DECISION DELEGATED TO HEAD OF PLANNING

Application No: H16-1191-25 **Applicant:** Tulip-Fields Homes Ltd

Proposal: Demolition of redundant commercial buildings and the erection of 4 dwellings

Location: 39-41 Albert Street Spalding

PROPOSED FIRST FLOOR PLAN

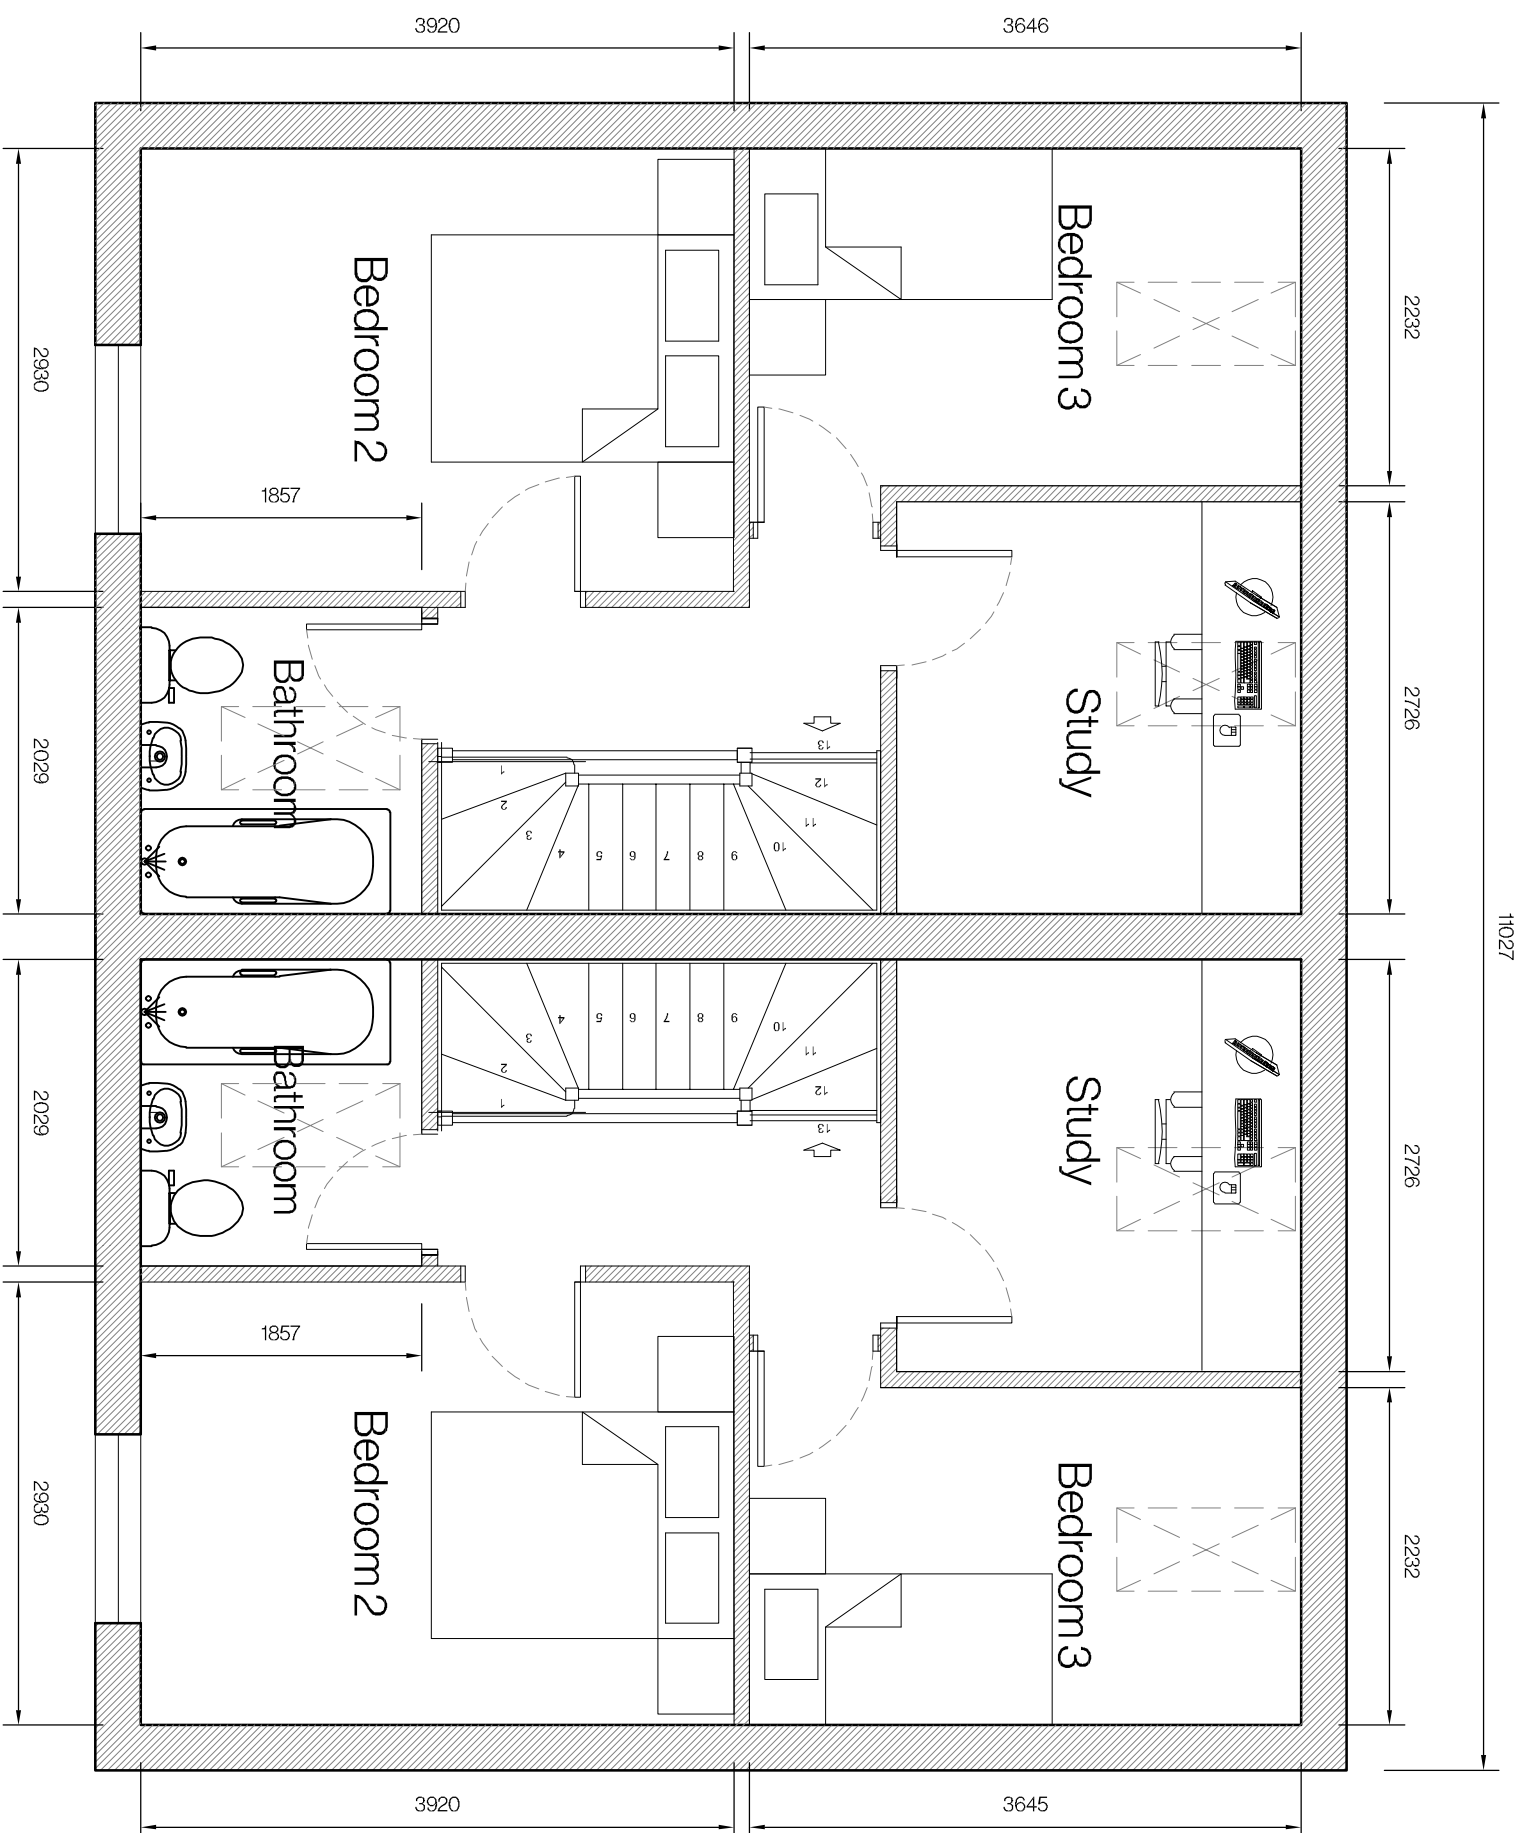
The proposed dwellings would be three-storey and of a significant height. Given the relatively low building heights in the immediate vicinity and the flatness of land, the proposed dwellings would be highly dominant in the street scene and would appear as an incongruous feature. The scale would immediately mark the dwellings as an incompatible feature, which breaks the existing peak of building heights. Paragraphs 53 and 56 of the NDG broadly outline that well-designed development should be influenced by the existing proportions and characteristics of the area. On this basis, as the development would be significantly taller than its immediate counterparts, the proposal would contradict these paragraphs of the NDG.

In addition to marking the dwellings as an incongruous feature, the significant scale in comparison to neighbouring dwellings would equally result in the development appearing highly prominent and overly dominant. The significant height means that the development would be visible within a larger area, including areas of Willow Walk/Osier Road, in turn resulting in a more impactful development. This would result in any negative effects being exacerbated, whilst also fundamentally altering the established character of the area and changing established architectural focal points in the area.

Due to the need to have no habitable space on the ground floor, the proposed living rooms would be on the first floor. The window serving these rooms all face south, towards Willow Walk. These properties do not have sizeable/useable rear gardens, although they do have north facing windows. Due to the orientation of the buildings, the windows of the proposed houses would look directly towards the windows of the relevant properties along Willow Walk. As a result, there would be a tangible overlooking effect, to the detriment of the residential amenity of the affected occupants.

PROPOSED STREET SCENE

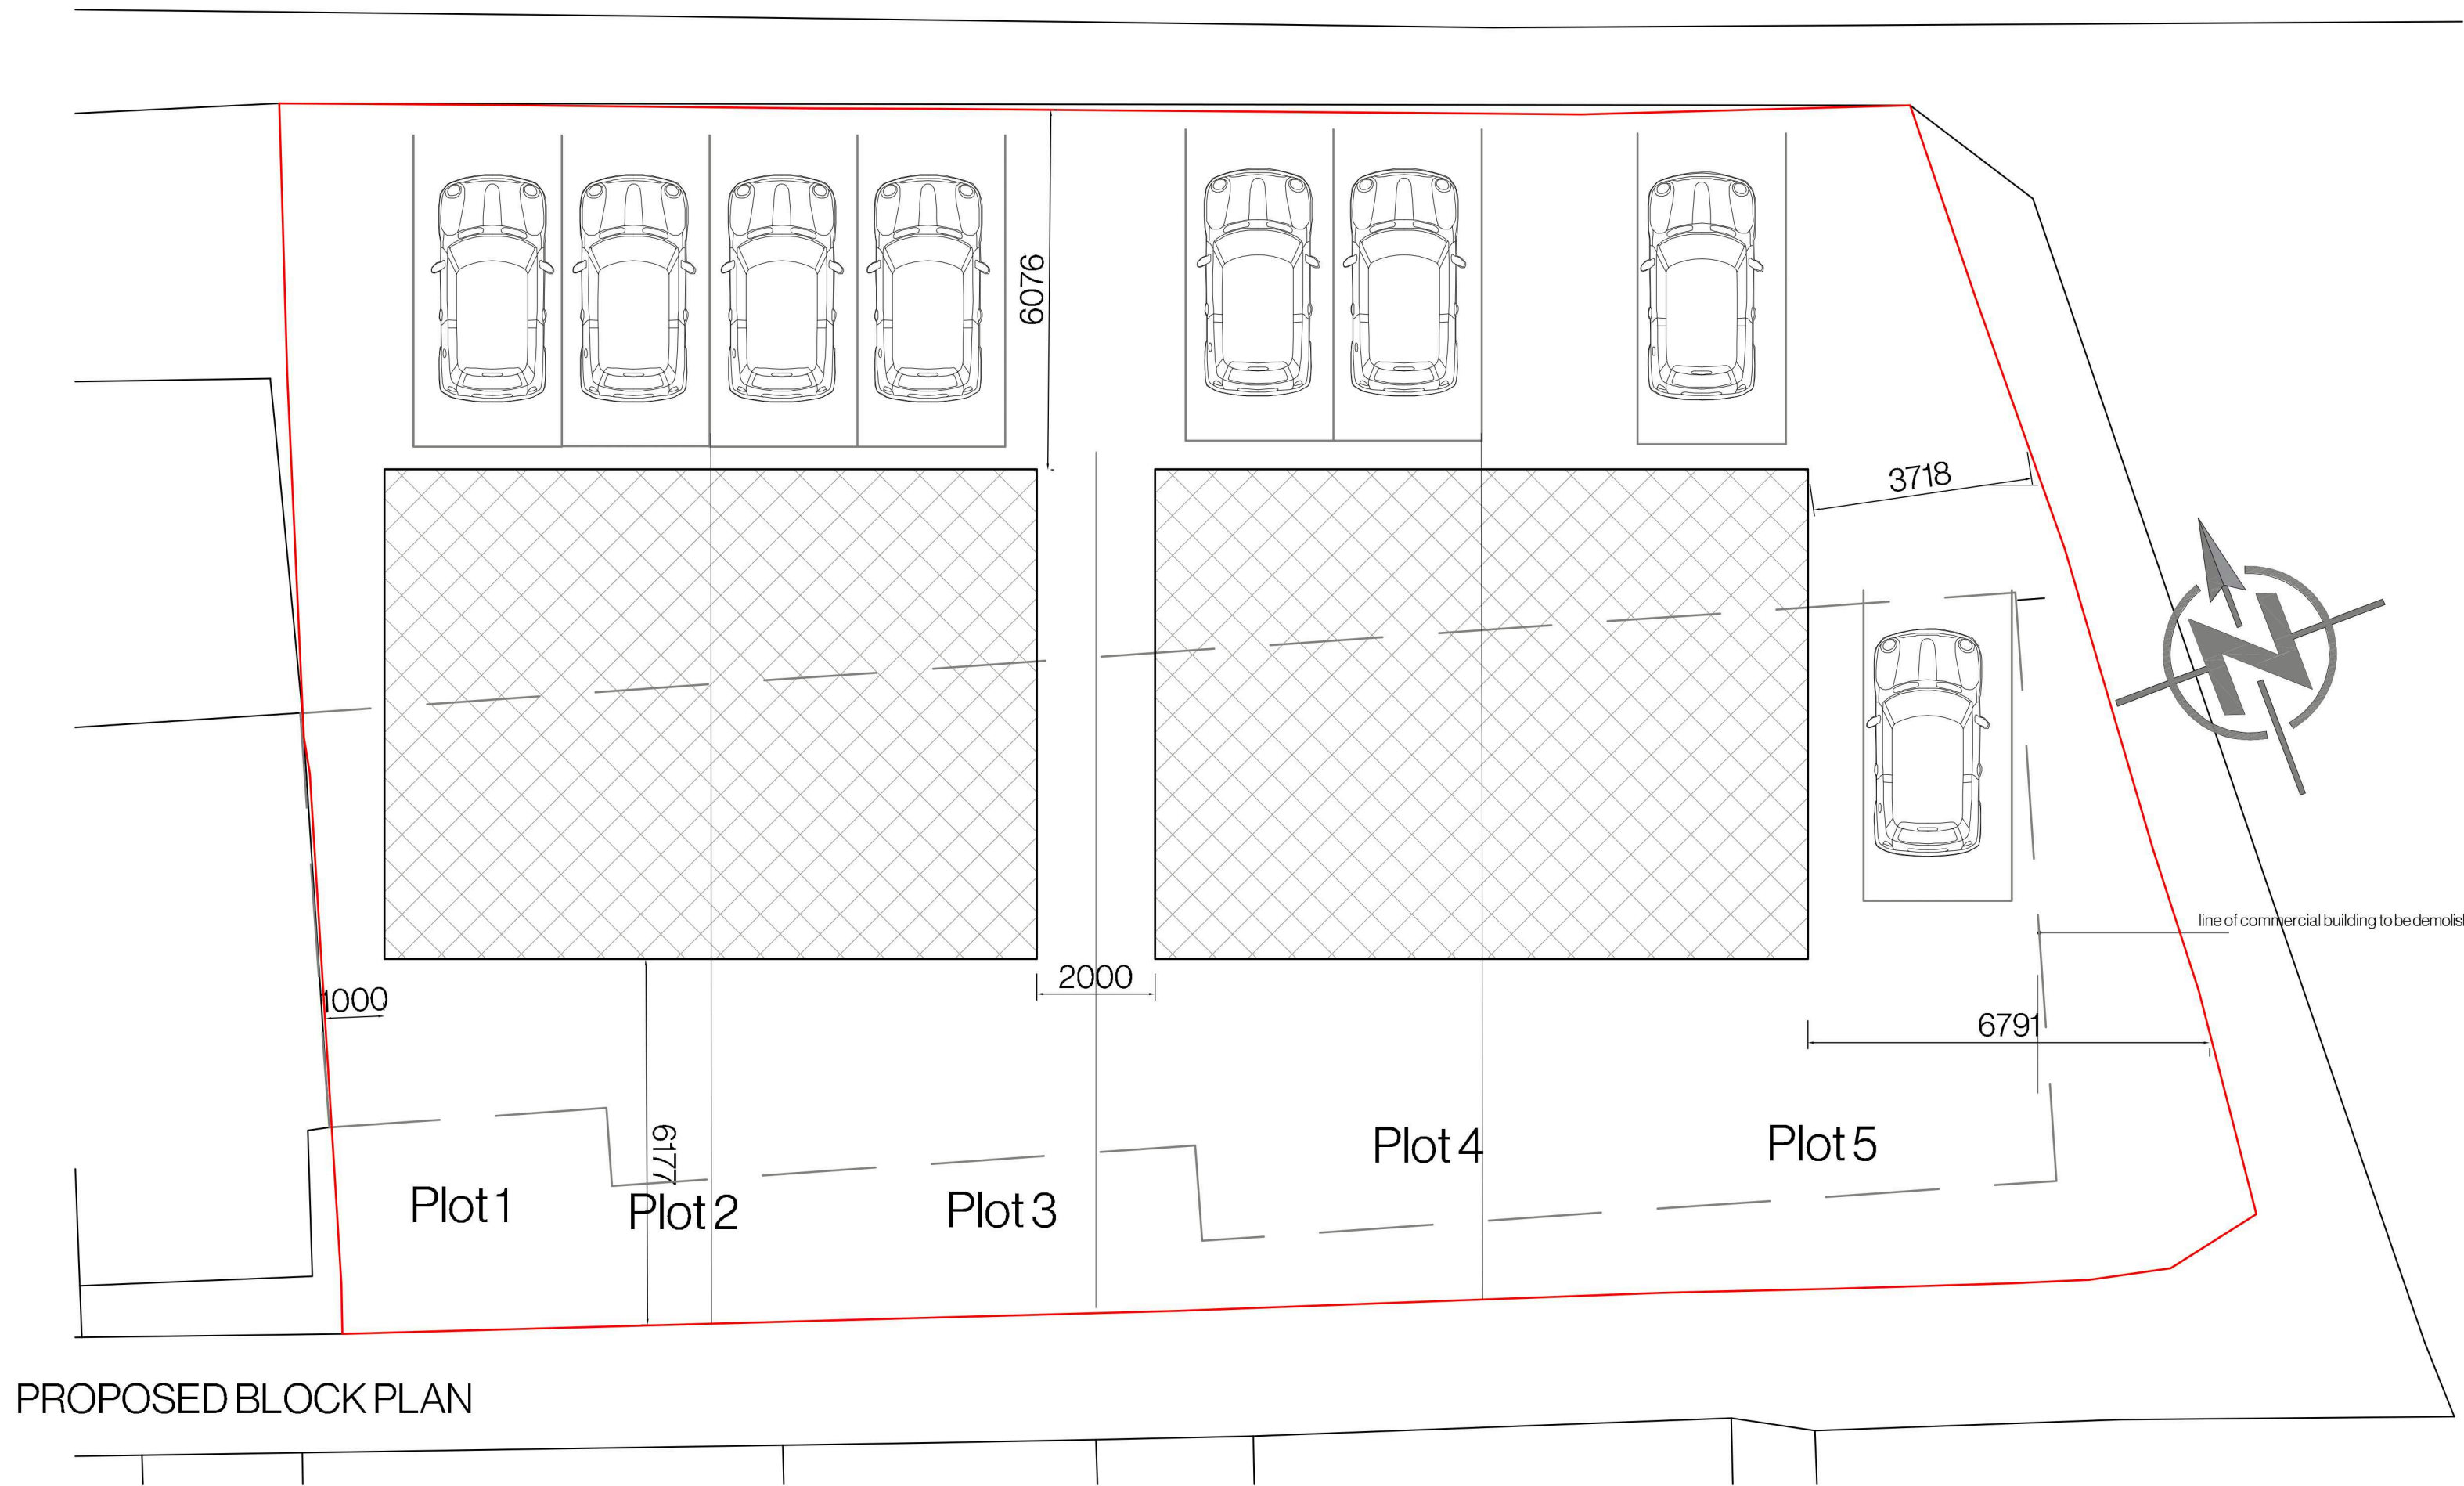
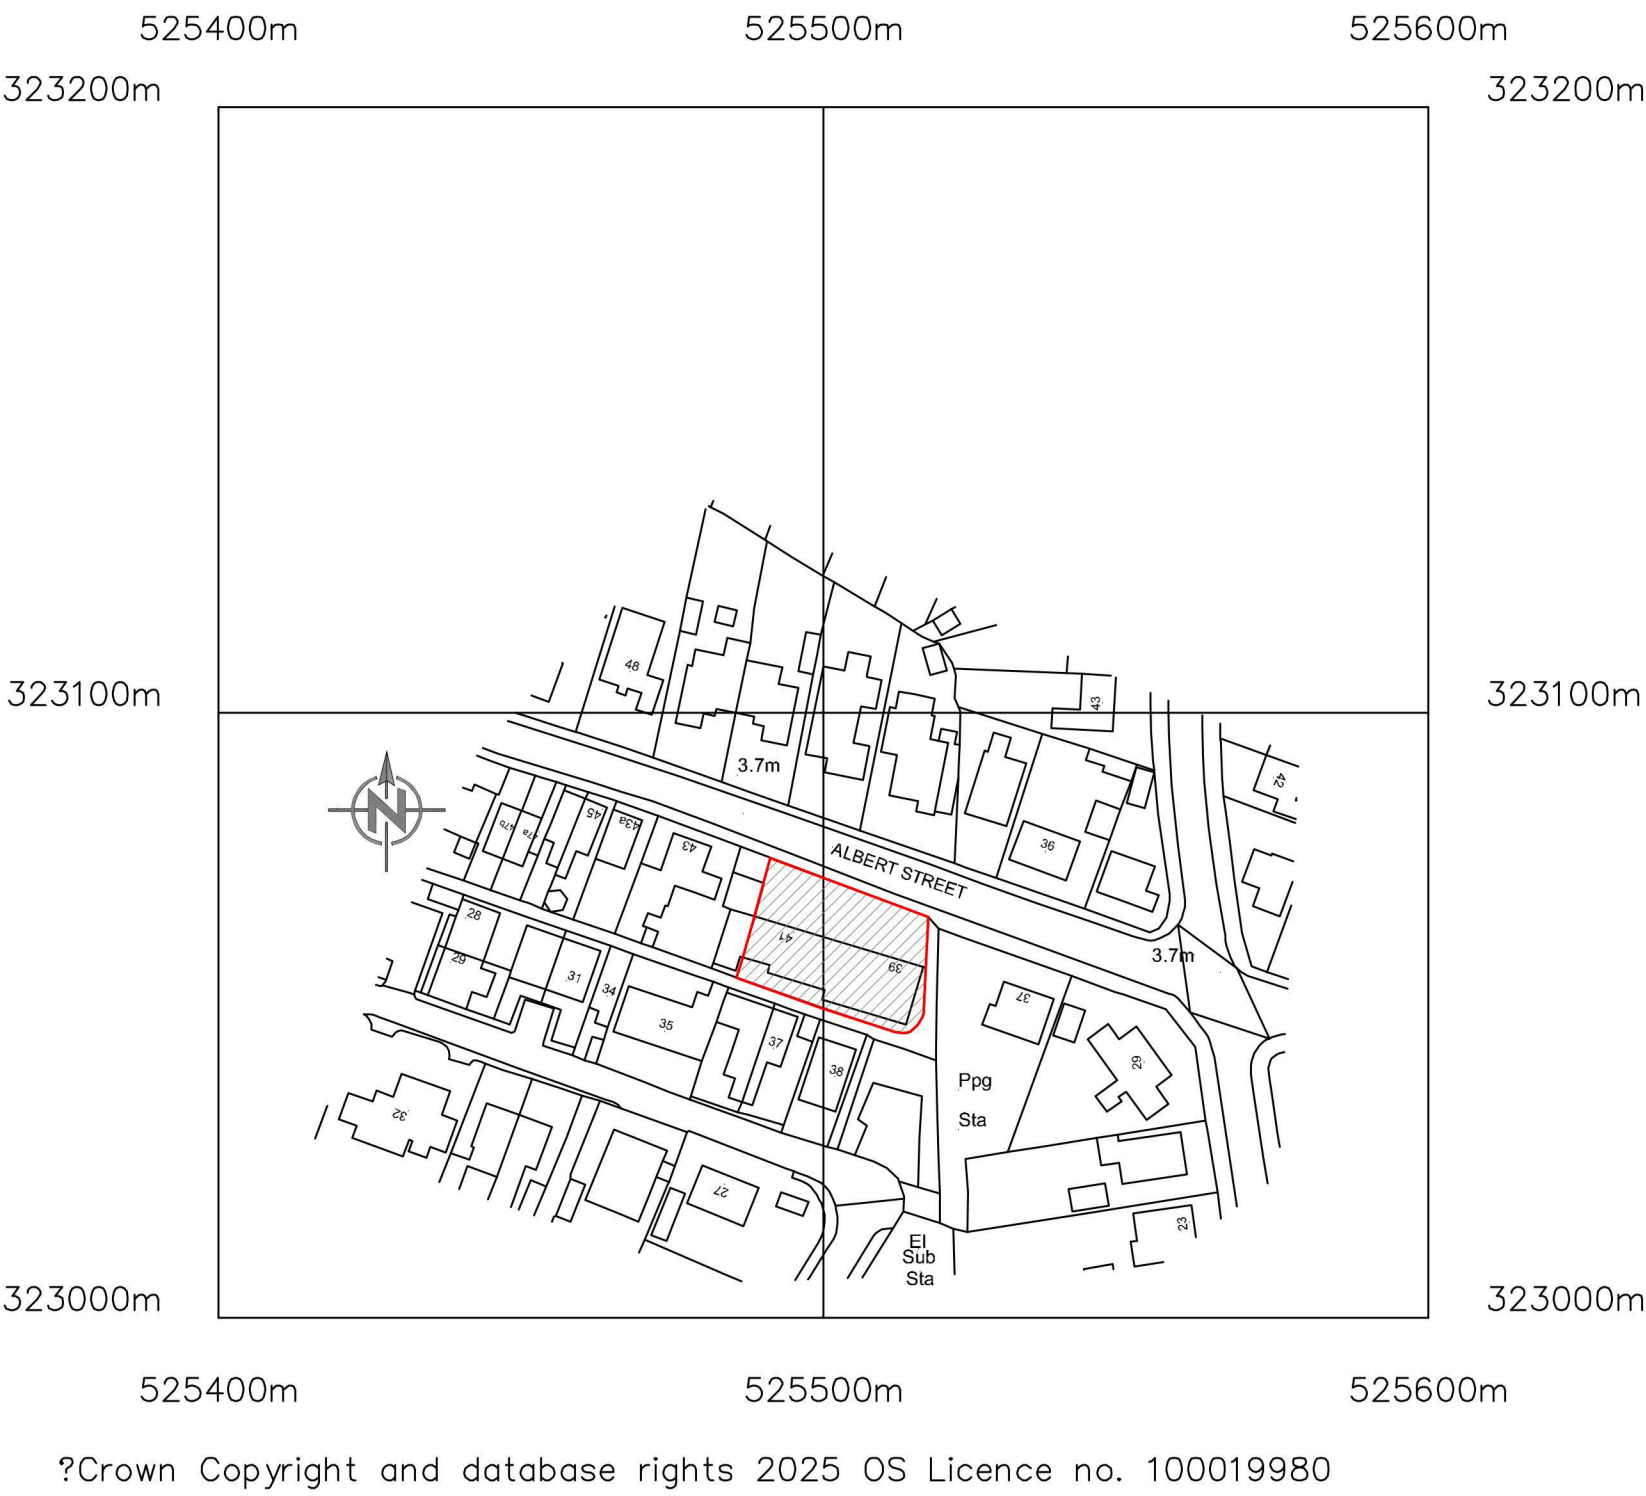
The whole of the frontage requires a dropped crossing - a note should be added to the proposed site plan to say it will be constructed to Lincolnshire County Council Specification.

The linear parking along the front should ideally be broken up with low level planting.

Please include the dimensions of the parking spaces on the proposed site plan.
